Please submit additional information & building application - Sign - 502 Stevens Ave1 message

From: Permitting and Inspections [mailto:buildinginspections@portlandmaine.gov]**Sent:** Friday, December 01, 2017 12:36 PM**To:** Denis Lachman**Subject:** Please submit additional information & building application - Sign & Awning - 502 Stevens Ave

TYP SIDE  
PROJECTING SIGN  
W 40" BRACKET  
502 DEERING CENTER  
NO SCALE 1.22.18  
LACHMAN ARCHITECTS & PLANNERS

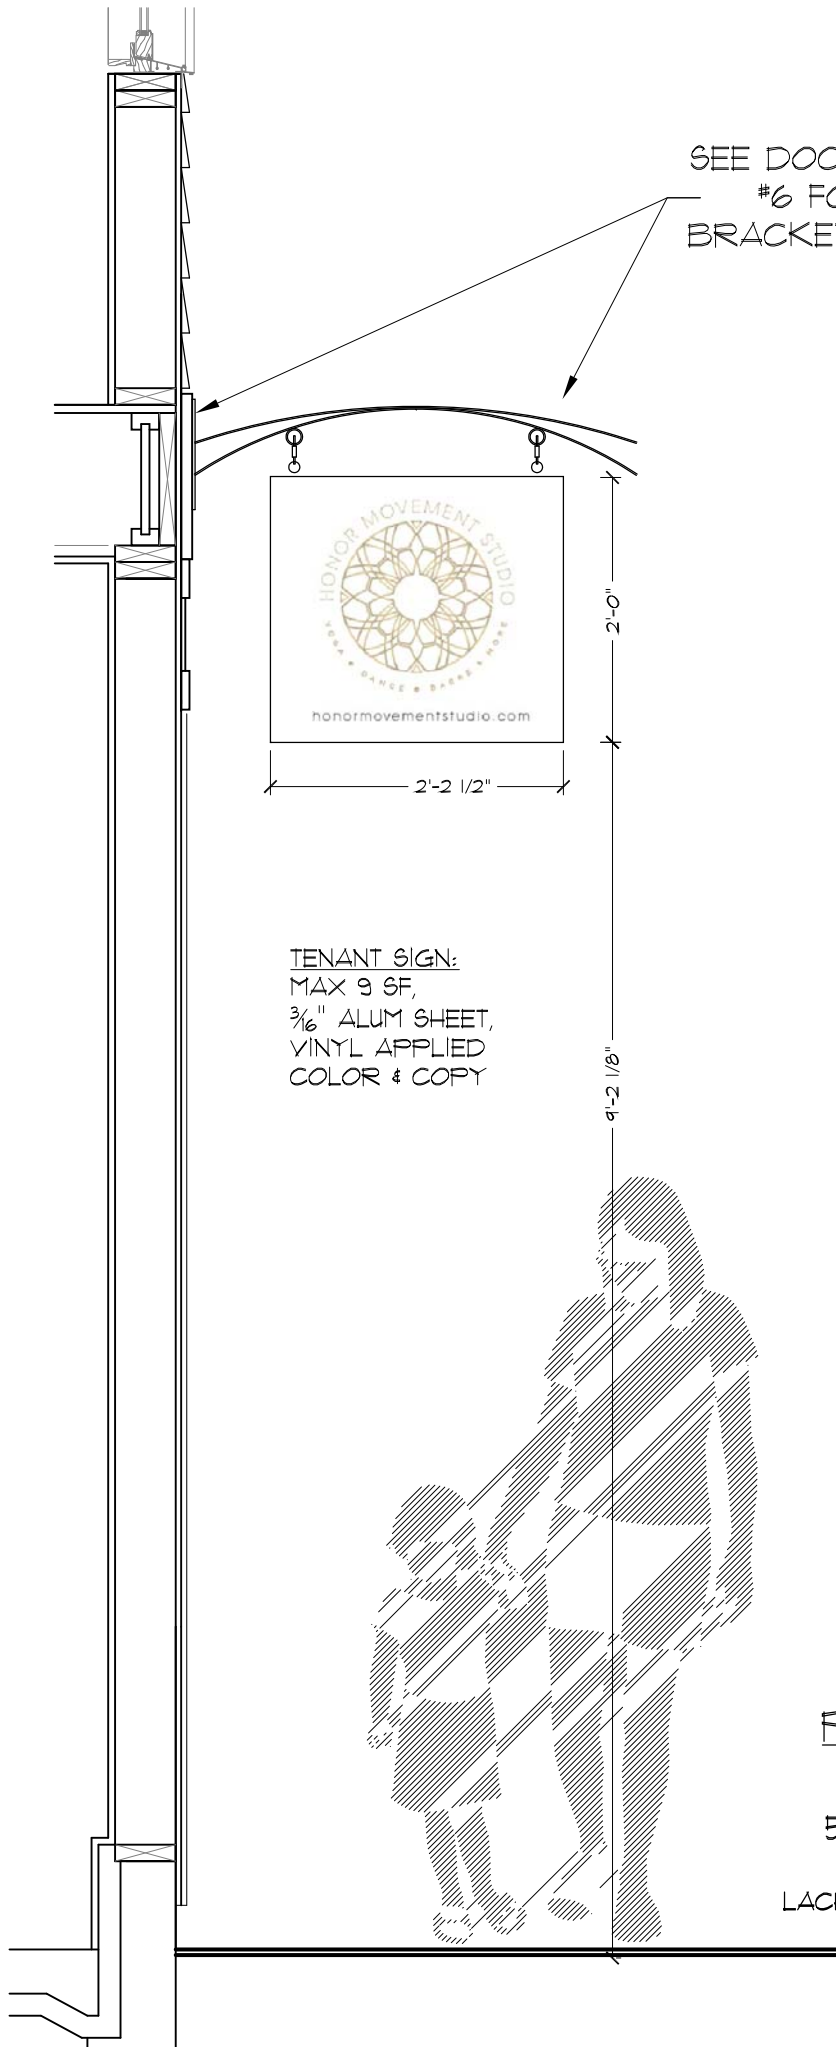
1. A mock up for each sign with dimensions, sign materials, design and name of the business appearing on each sign.

Document #5 Sign Details (attached) shows a typical sign, with dimensions, materials and name of typical business. Please keep in mind Section 14-369.5 regulates the number of signs and their area. However, because copy (shape, color, message, font etc) is speech, it is not subject to regulation.
